Appeal Decision

Appeal Ref: APP/R5510/D/20/3249442

28 Howletts Lane Ruislip HA4 7RS

proposed front elevation

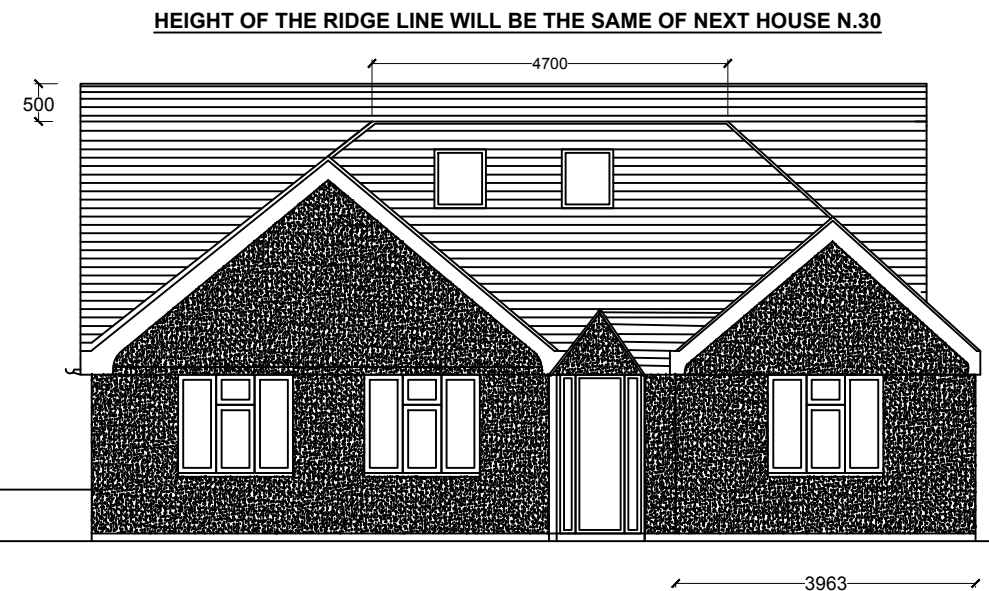
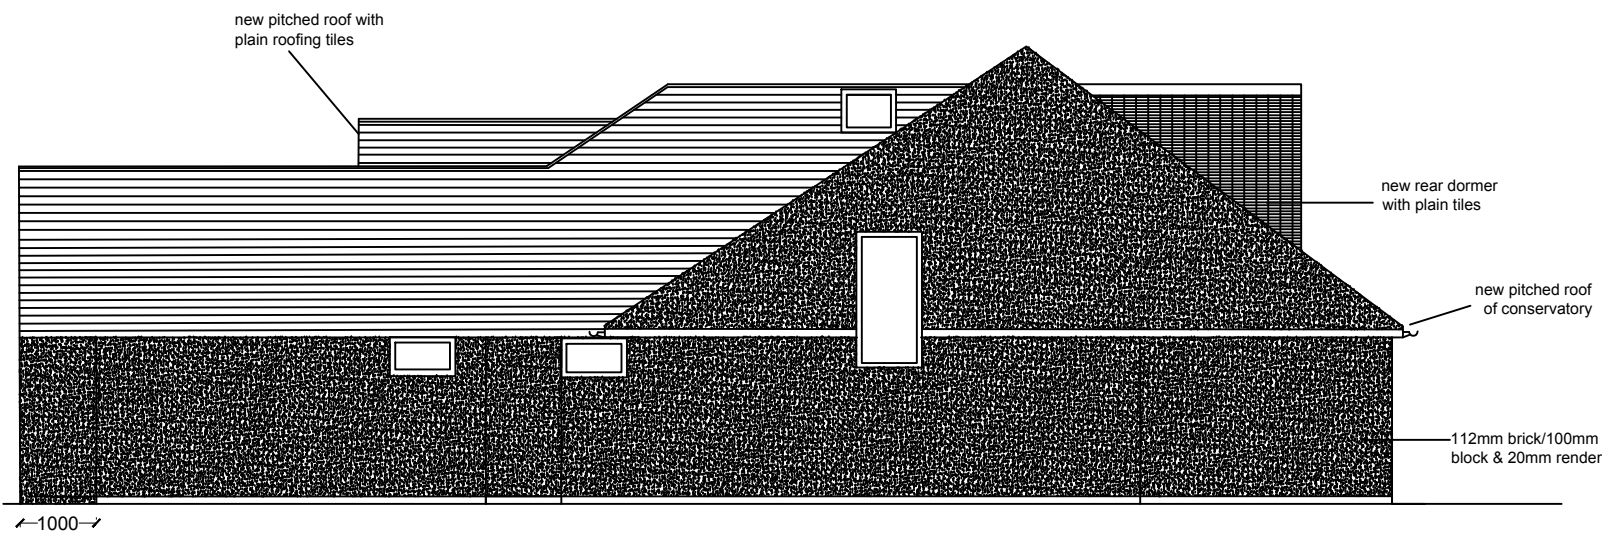
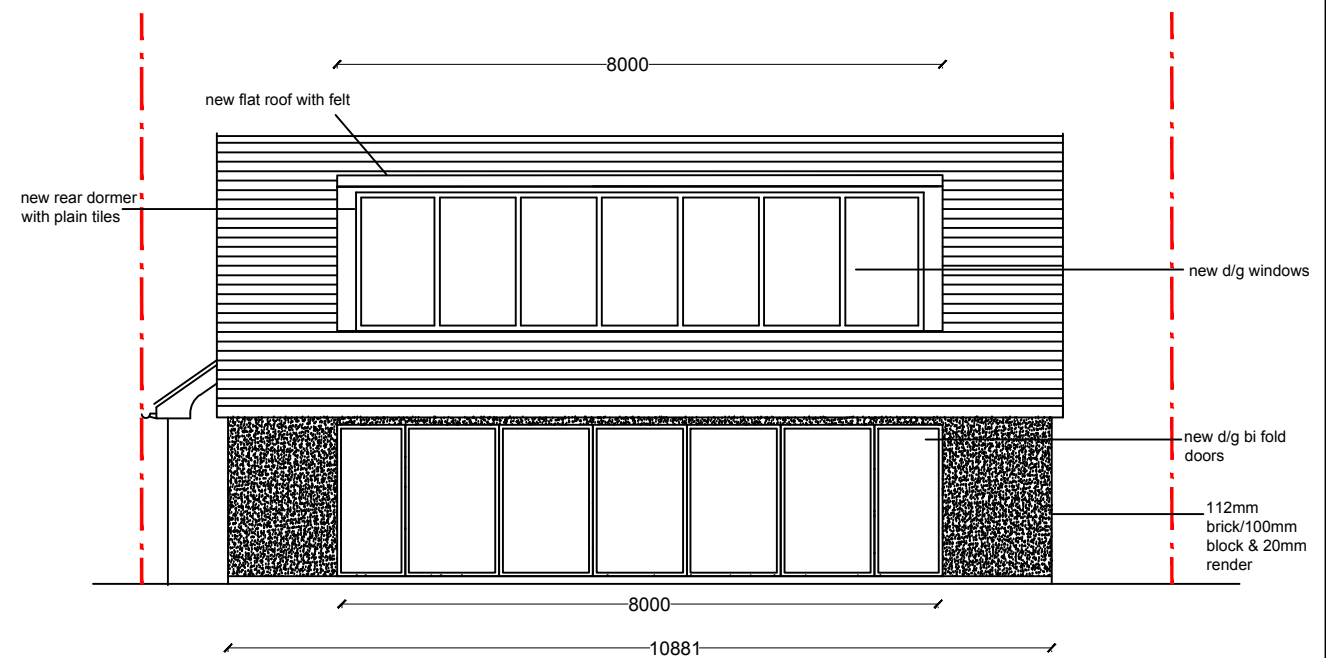
8. The proposed extensions to the front of the dwelling would be apparent as seen from Howletts Lane, however the tallest part of the building would not exceed the height of the adjacent building, number 30. The form and design would echo that of number 30 and as such I am of the opinion that this would not cause harm to the character or appearance of the street. The proposed materials are to match that of the existing roof, and this, together with the

9. Due to the site's location adjacent to a public right of way (to the south), the side extensions would be partly visible but would not alter the character significantly. As seen from the rear, the dormer extension would be glimpsed only due to the tall vegetation present to the rear boundary. Notwithstanding this, I am of the opinion that the proposed development would not significantly harm the character or appearance of the area. Notwithstanding the overall mass and scale of the development, I do not consider that the proposed development would be harmful to the character or appearance of the streetscene.

proposed roof plan

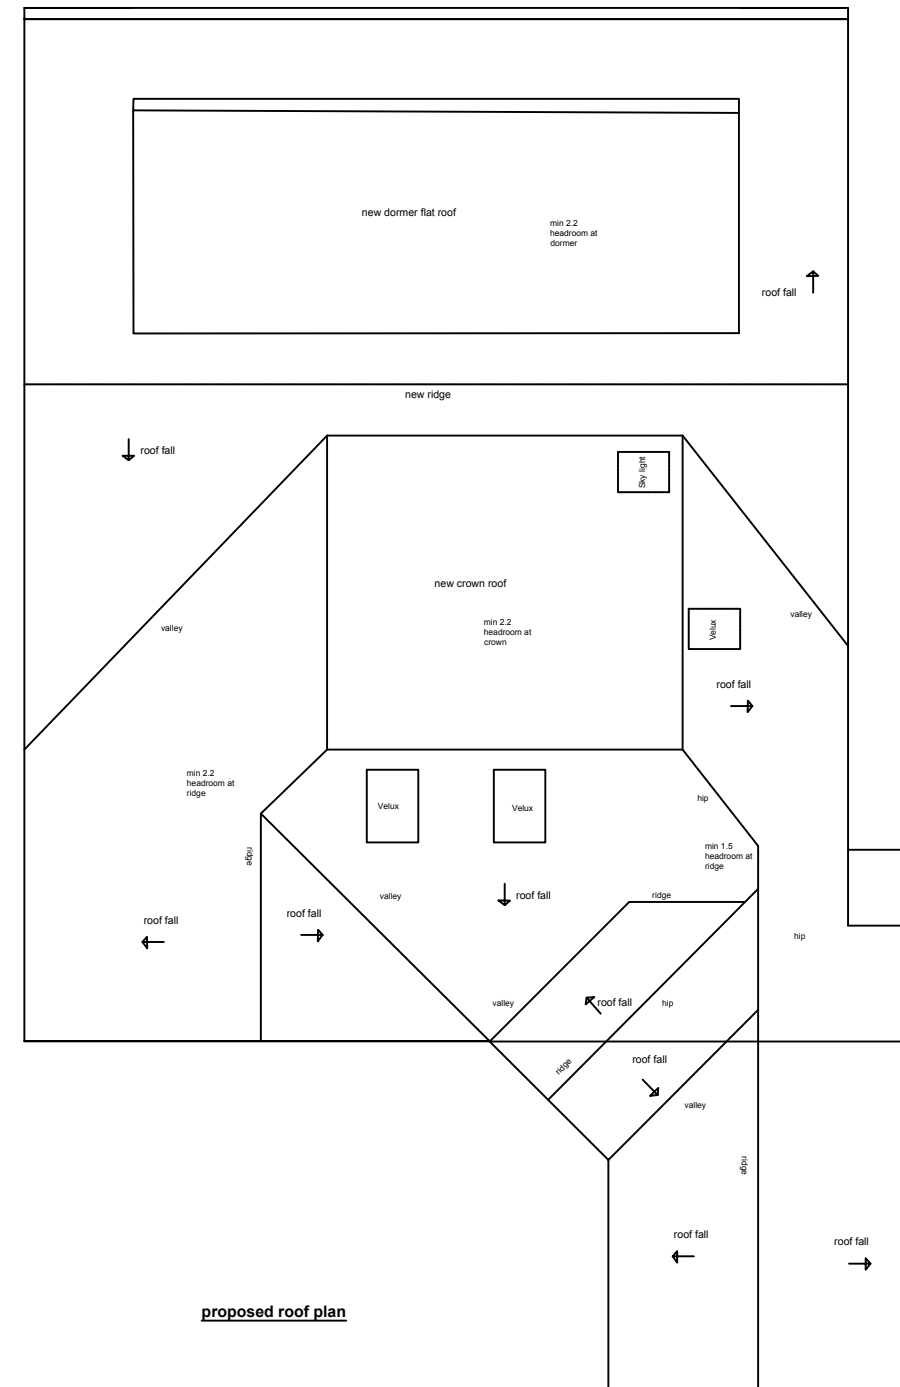
6. The proposed development would increase the height of the existing dwelling by raising the roof making use of the existing gable elements and providing a 'crown roof' addition. This would incorporate rooflights to the front and side elevations. The existing footprint would be utilised to provide an extension across the width of the dwelling, and incorporate a flat roofed dormer extension to the roof. This is a large extension of the property which makes use of the existing built form. The resultant development would have varied ridgelines, with the original front gables being retained.

7. Policy DMHD 1 of the Hillingdon Local Plan² ("the Local Plan") sets out criteria for roof extensions, including a requirement that roof extensions should not create a dominant 'top heavy' appearance out of proportion with the rest of the building. Whilst the extensions proposed are sizeable, the design takes its cues from the existing dwelling, matching the pitch of the existing roofslope as well as the designs of the neighbouring property at number 30 Howletts Lane. The proposals also respects the original dwelling, with the front gable features largely untouched. The crown roof extension would allow the original building to retain its character and appearance, whilst enabling the extension of the property. Although the development is substantial in size, it does not diminish the size of the garden or the plot of the appeal site. Therefore, the proposed extension would comply with the requirements of Policy DMHD 1.

10. The dormer window to the rear, whilst large, remains below the ridge of the dwelling and the window arrangements would match the proposed bi-fold doors to the ground floor. The dormer would remain set in from the edges of the main roof and would be located to the rear. I consider that there would not be consistent or dominant views of the dormer window from either Howletts Lane or Thames Way and as such would not cause harm to the character or appearance of the streetscene. The original features and character of the dwelling would be retained, in particular those to the front elevation of the property. The overall form of the building would not be affected, and its contribution to the character and appearance of the street would not be weakened.
